**Re: Bedrock at The Trails Units 2 and 3 at 9300 Woodmont Ave. NW
Erosion and Sediment Control Plan
CPESC Stamp Date 11/21/24 & PE Stamp Dates 7/18/24 & 7/31/24 (C09E011B)**

Based on the information in your submittal received on 11/26/24 consisting of Sheets ESC 1-3, the DMP, and 39R and 40R of the Phase 1 work Order Plans, the following comments must be addressed before approval.

POND D1 CROSS SECTION
SCALE: NOT TO SCALE

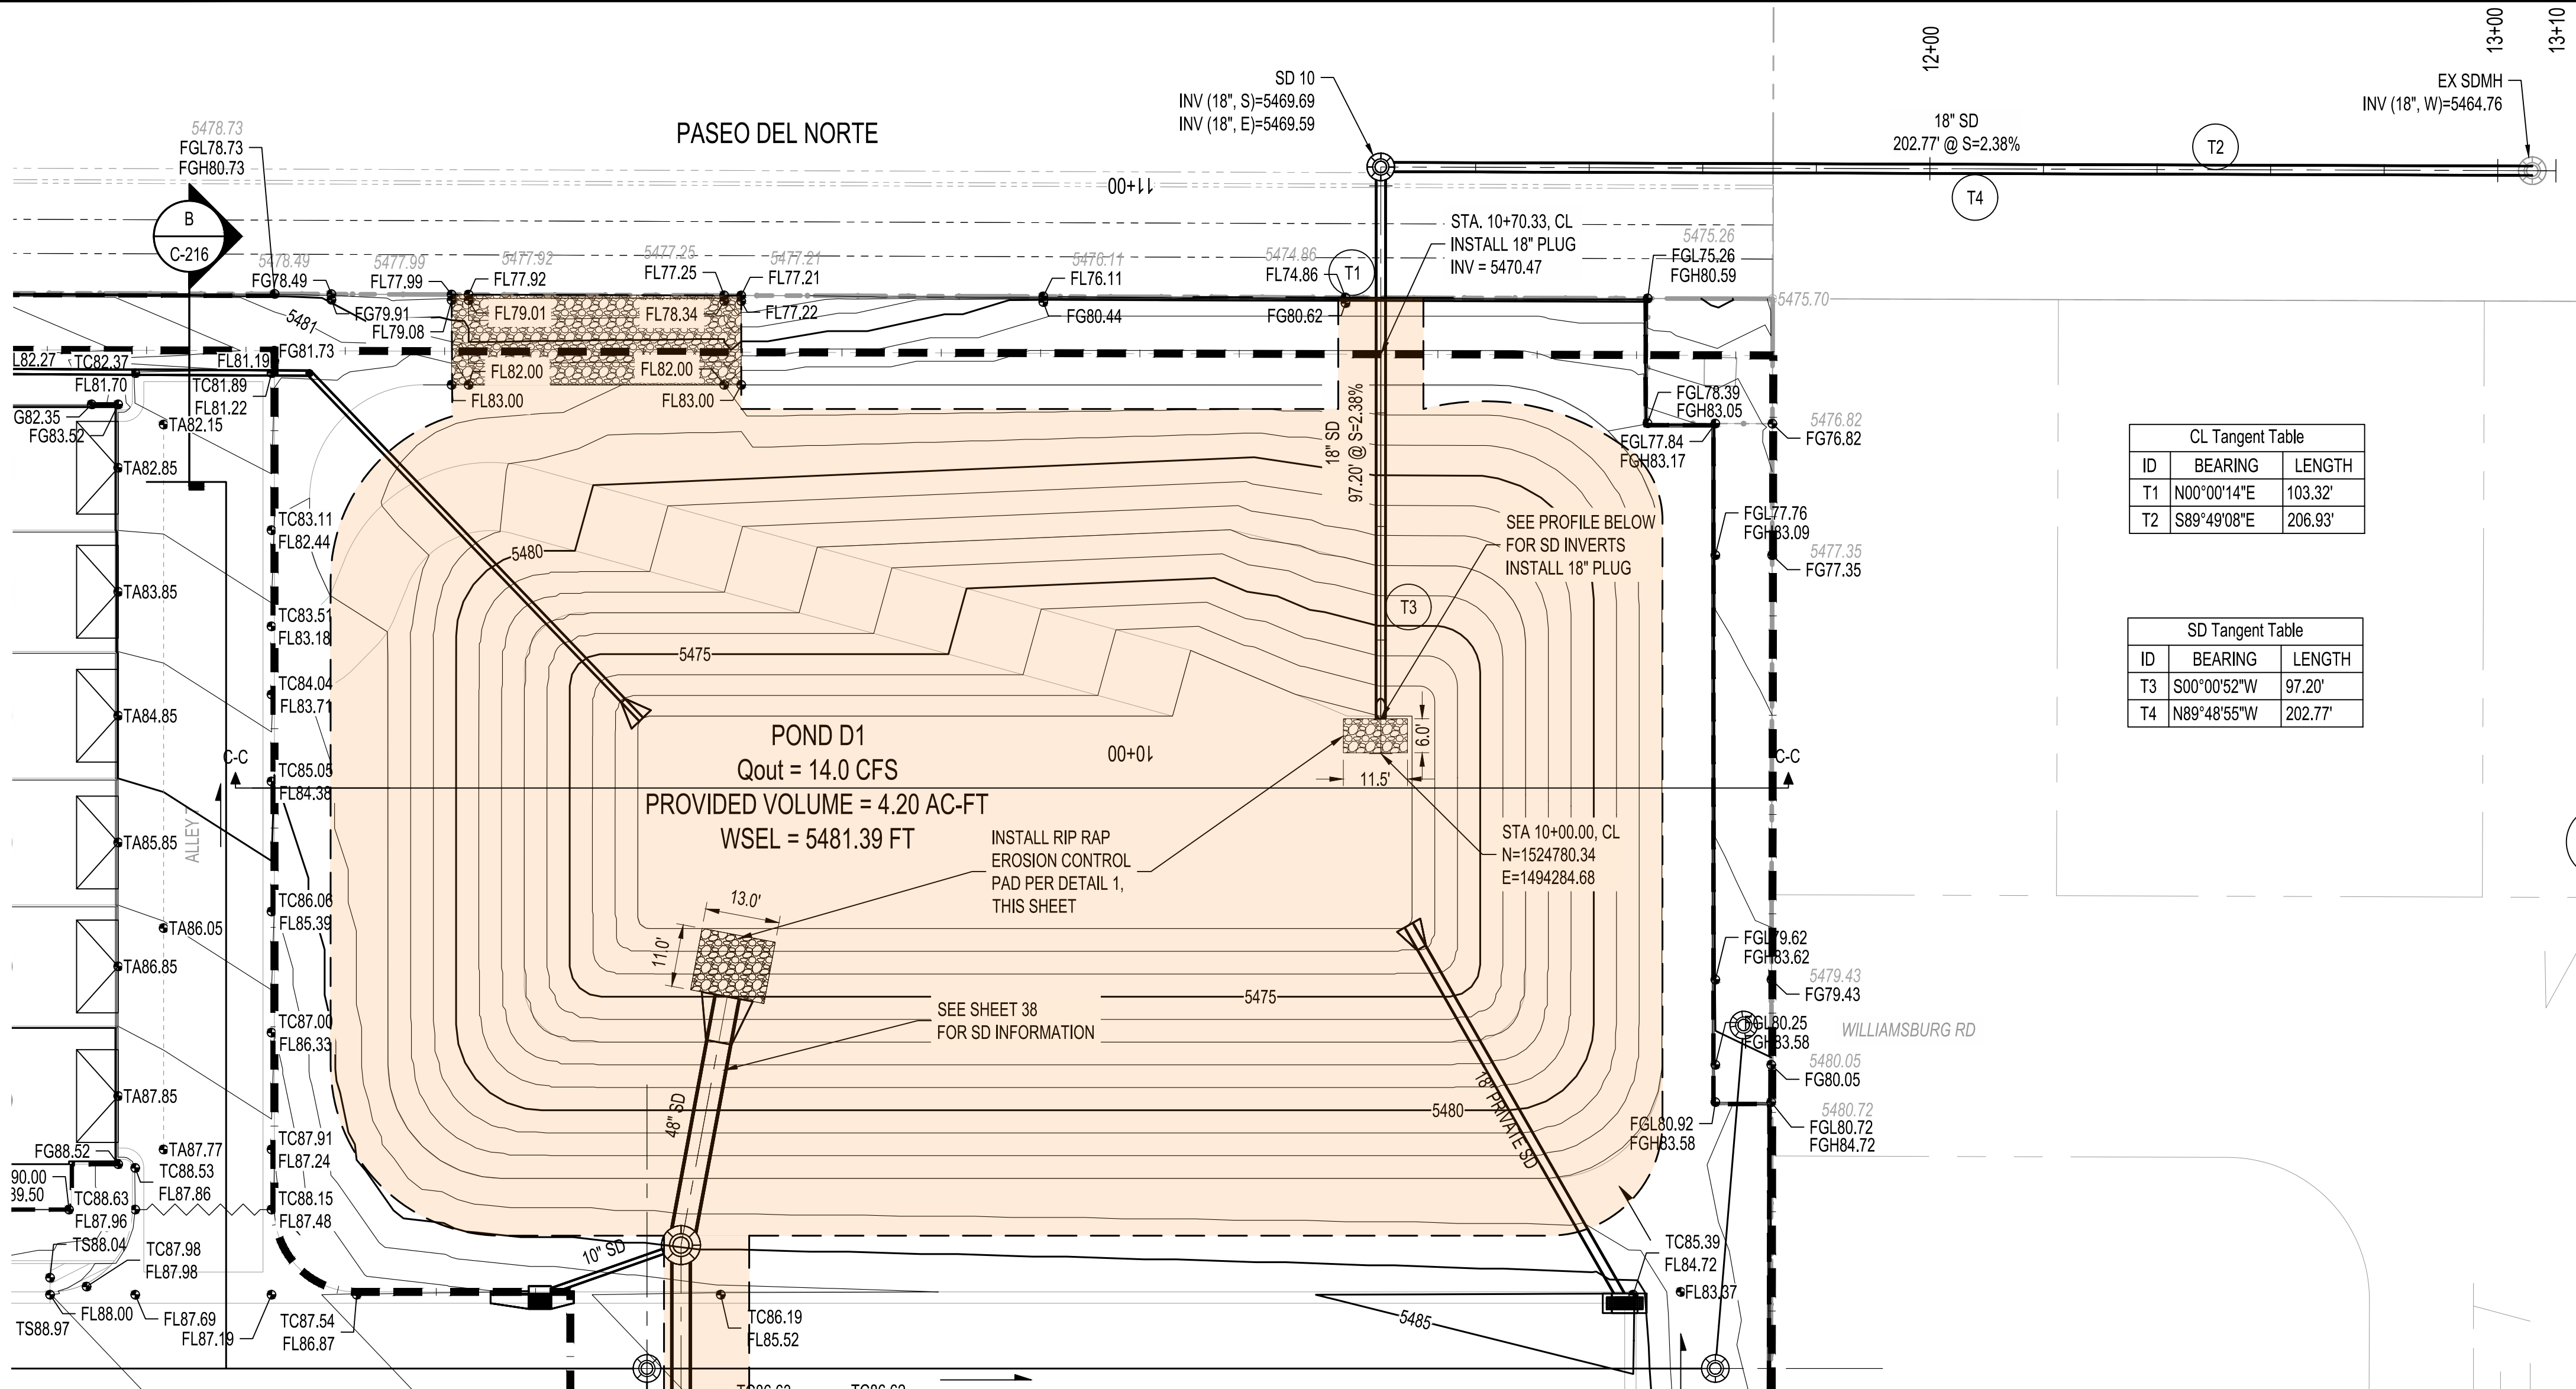
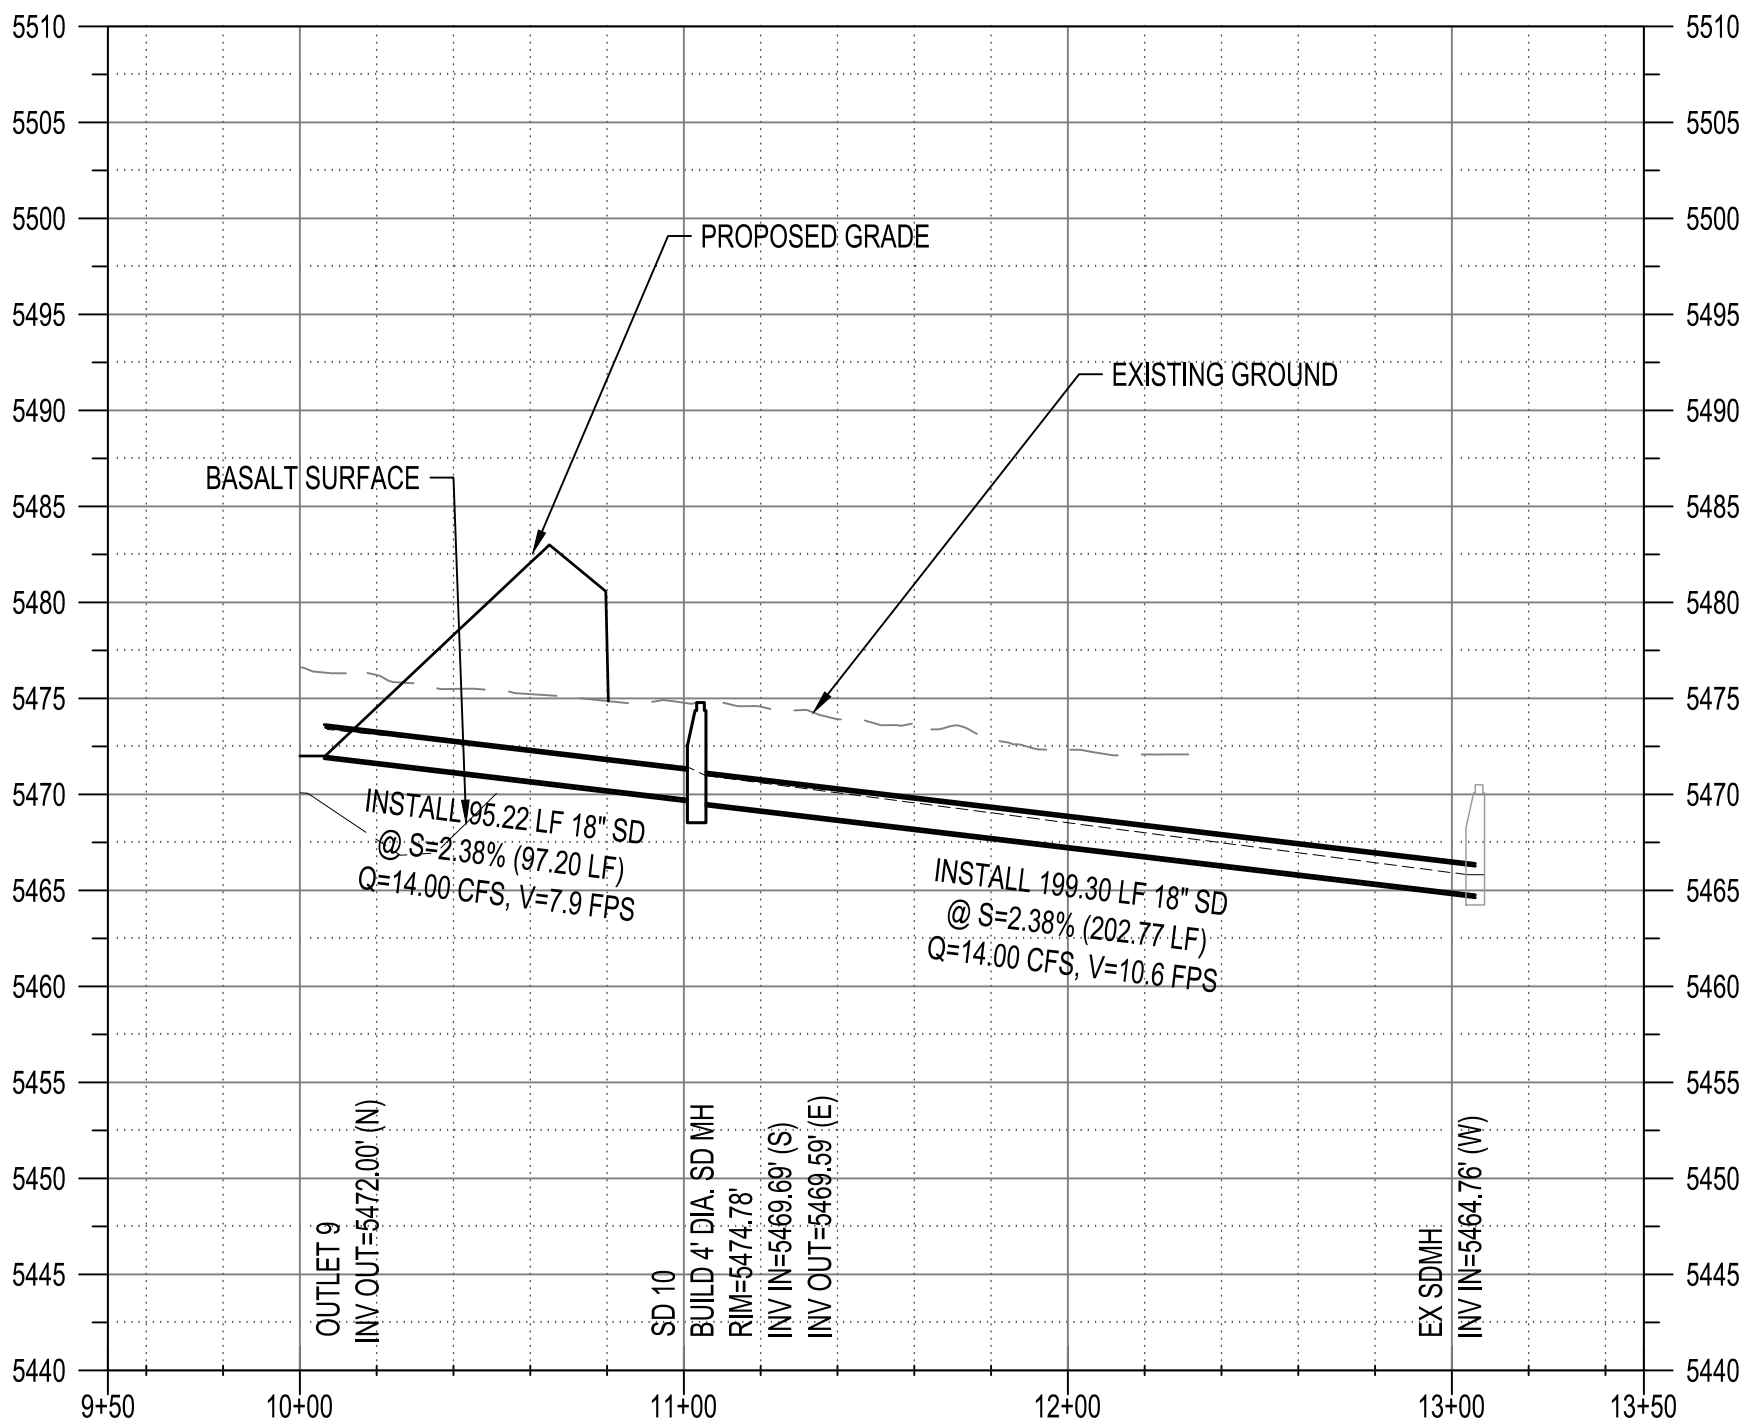
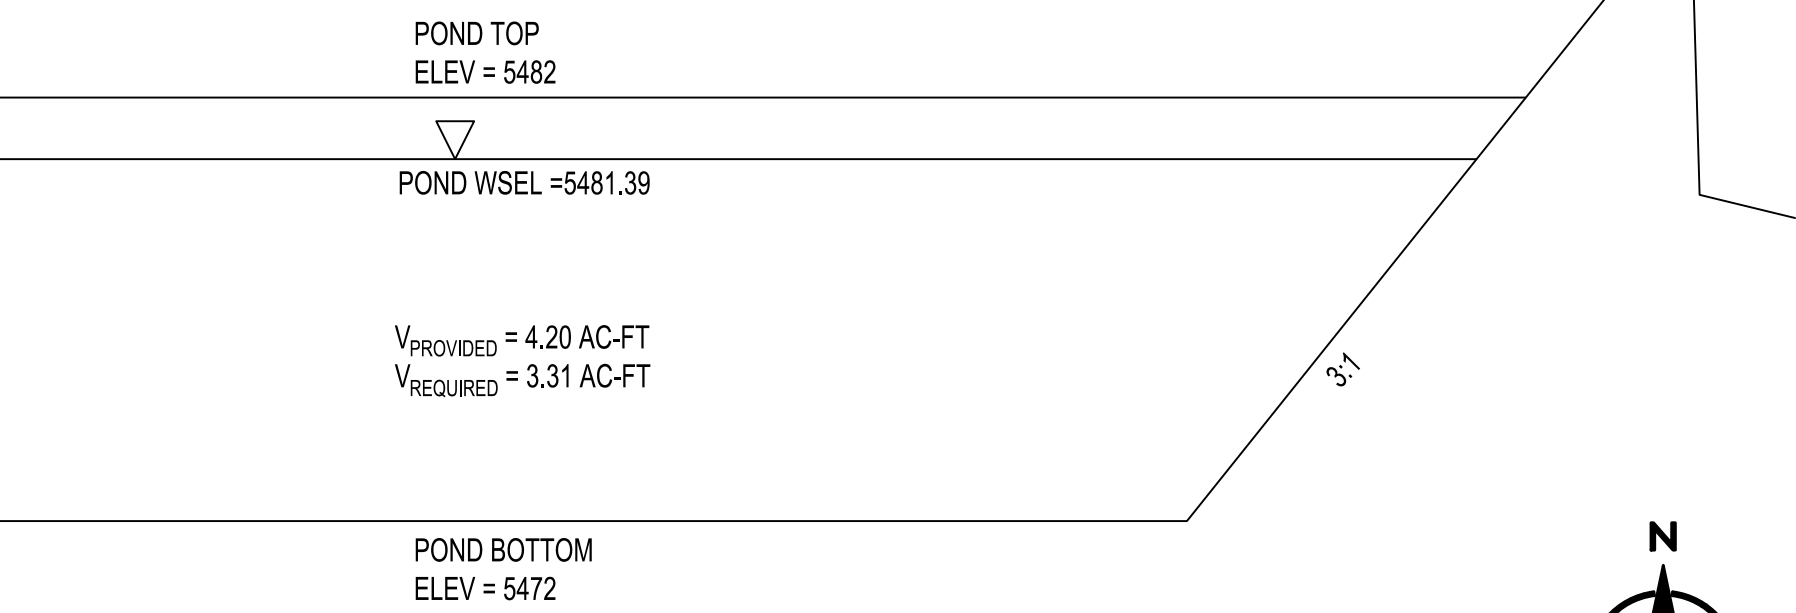
1. The construction sequencing on sheet ESC-2 says, in essence, that the outfall pipes from ponds D1 and A6-2 will be plugged until all of the buildings and infrastructure construction and stabilization are complete. However, the engineering sheets don't indicate that that condition is safe, nor is there any indication that the condition has even been considered by the professional engineer (PE). So, provide a hydrologic summary of how those two ponds will function with plugged outlet pipes at full buildout. The summary should be stamped by a PE and included in the Work Order and ESC Plans. The summary should include a description of the conditions, the 2-yr and 100-yr 24-hour volumes, peak flow rates, and peak stages in all ponds.

2. The plugs should be specified on the Work Order Plans as RCP Caps with gaskets or approved equal.
3. Specify on the Work Order Plans the timing of the cap removal, sediment removal, fine grading, and final stabilization per STD Spec 1013 for all onsite ponds acting as temporary sediment basins.
